**From:** Brian Banister [REDACTED]  
**Sent:** 26 March 2022 10:14  
**To:** Planning.Responses <Planning.Responses@arun.gov.uk>  
**Subject:** Y/23/22/HH - Single storey side extension - 1 Tillington Cottages, Main Road, Yapton

In respect of the above planning application the **Arun District Conservation Area Advisory Panel** wish to make the following comments:

Site Block Plan as Proposed 1:500

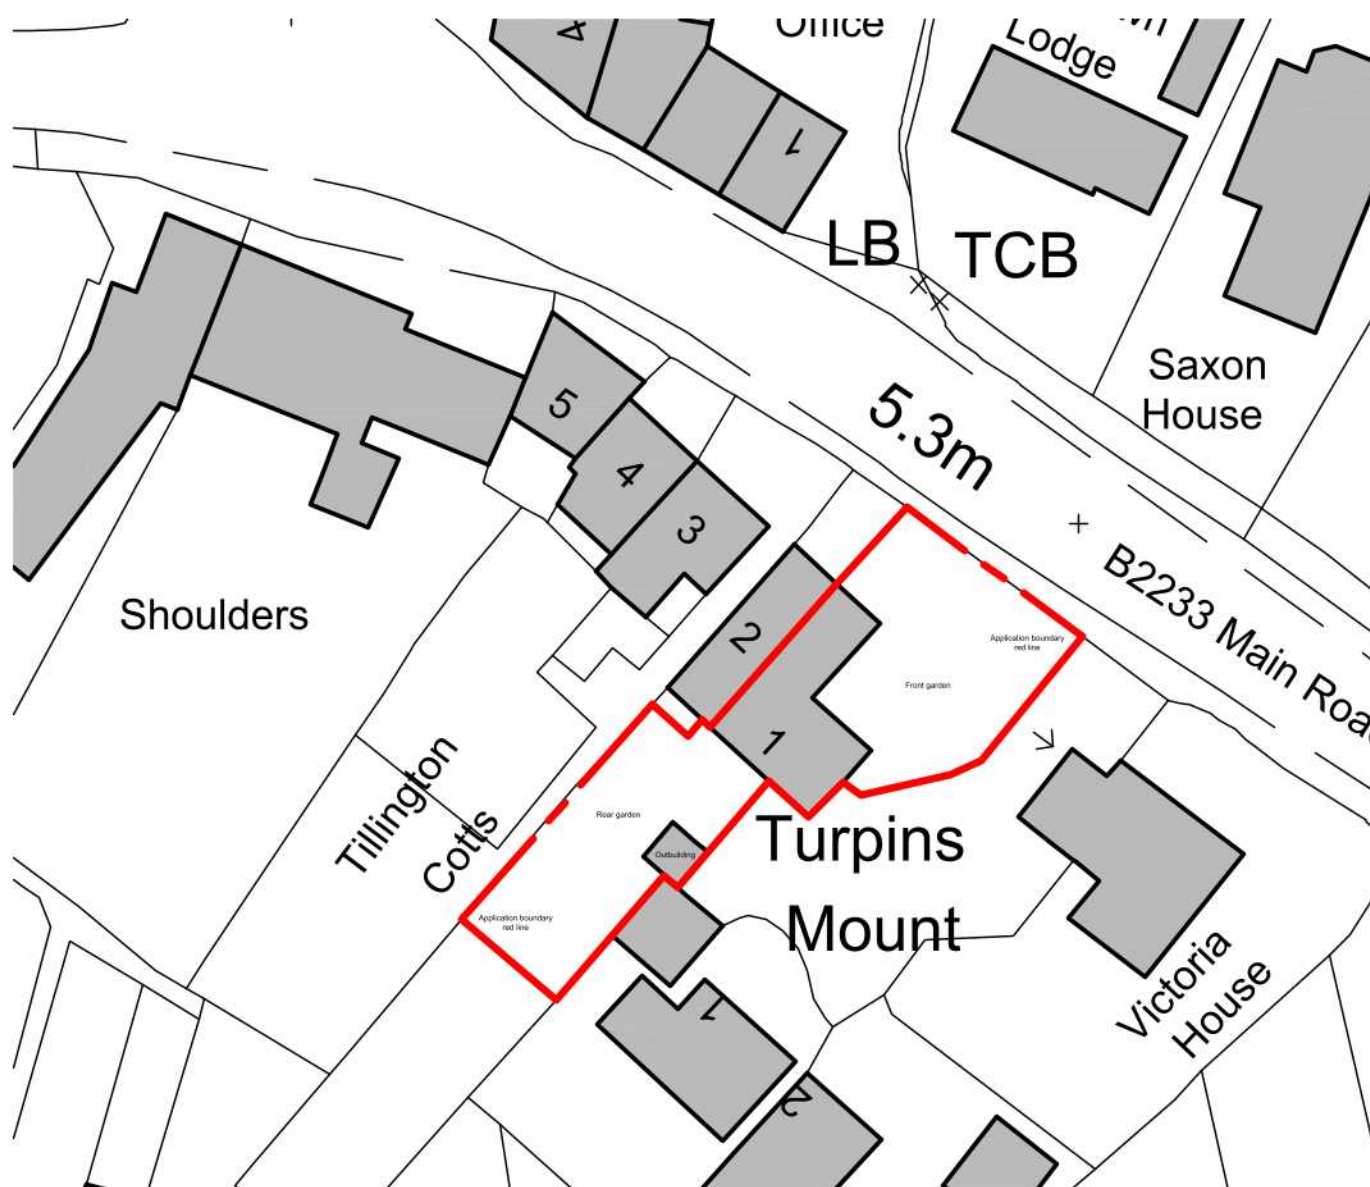
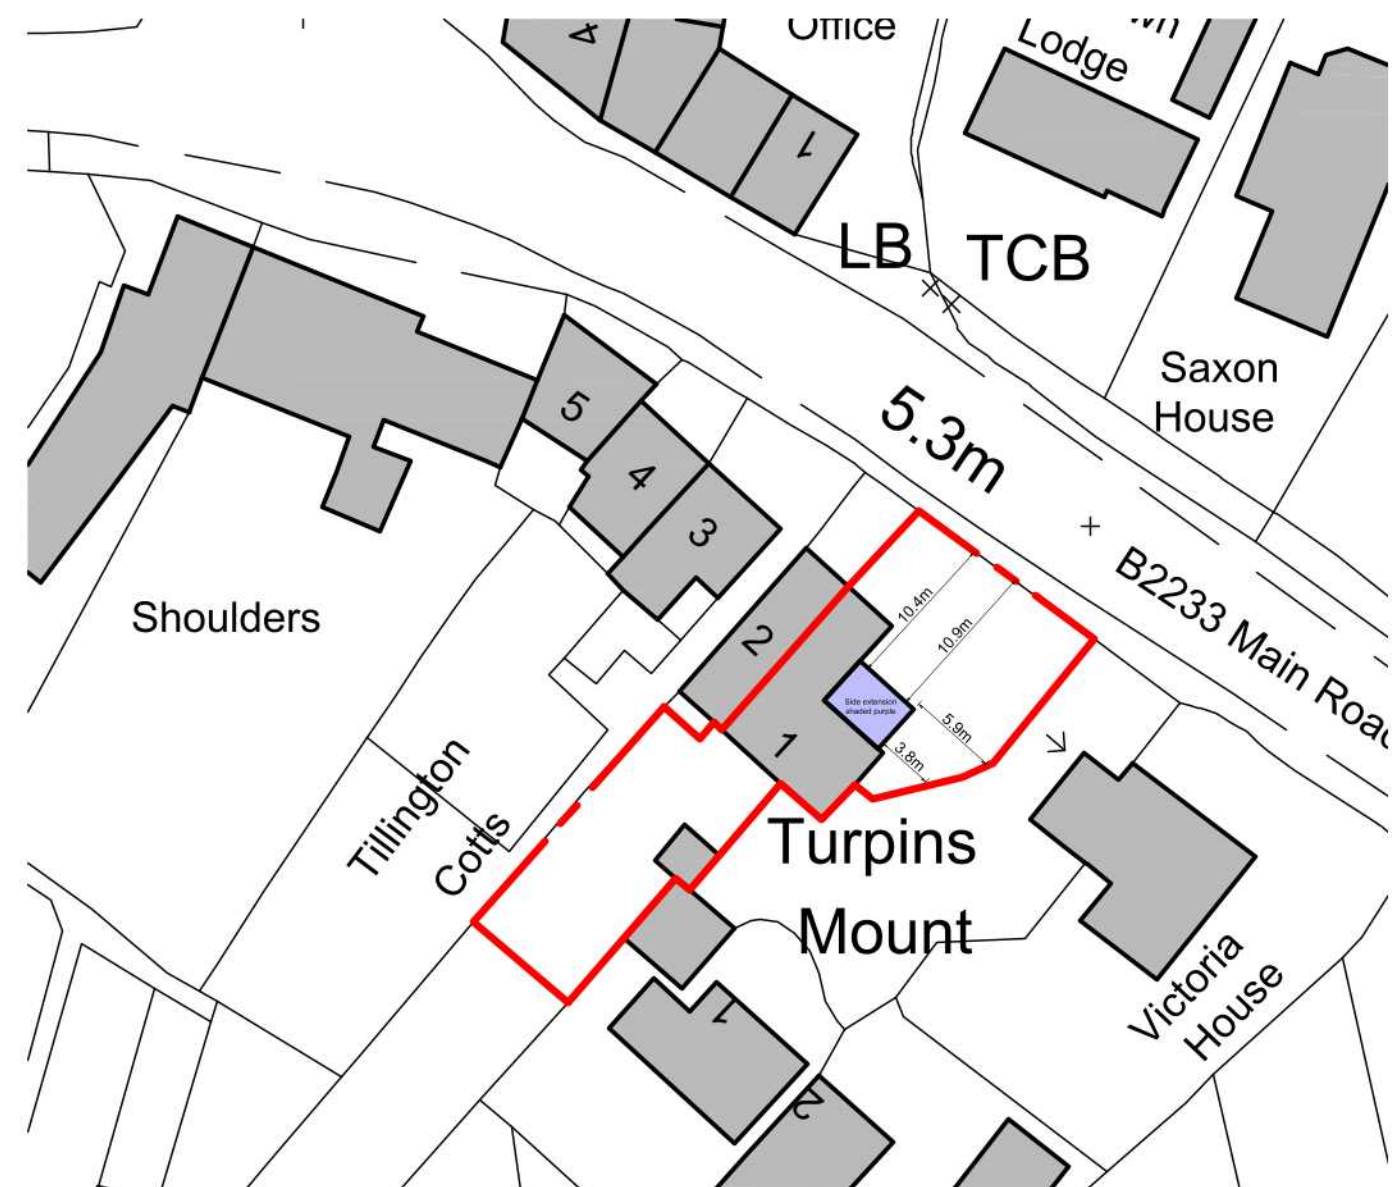
The proposal includes extending the existing single storey, flat roofed, rear and side extension forward towards the front of the host building. Although still set back from the front elevation of the main building, it will potentially be more prominent in the street scene. In addition, at 4.8 metres in width and with a flat roof it will appear incongruous in relation to the pitched roof host building and the street scene which contains structures of traditional form and appearance.

It will appear out of keeping with the conservation area, in relation to the group mentioned above, Turpins Mount and with the adjoining Victoria House which has a relatively modern extension on its west side but which is of traditional form and detailing.

In order to overcome these concerns the proposed extension could incorporate a double pitched roof with a hipped gable and with the main ridge line running parallel with that on the host building. If this were done, then the extension could be made a little wider (say 5.0m instead of 4.8m) in order to provide a useful break in plane on the south east elevation between the existing flat roofed structure and the new pitched roof extension.

If the Council decides that it could not insist on a pitched roof then the possibility of introducing a parapet on the front elevation rather than a bulky fascia board should be considered.
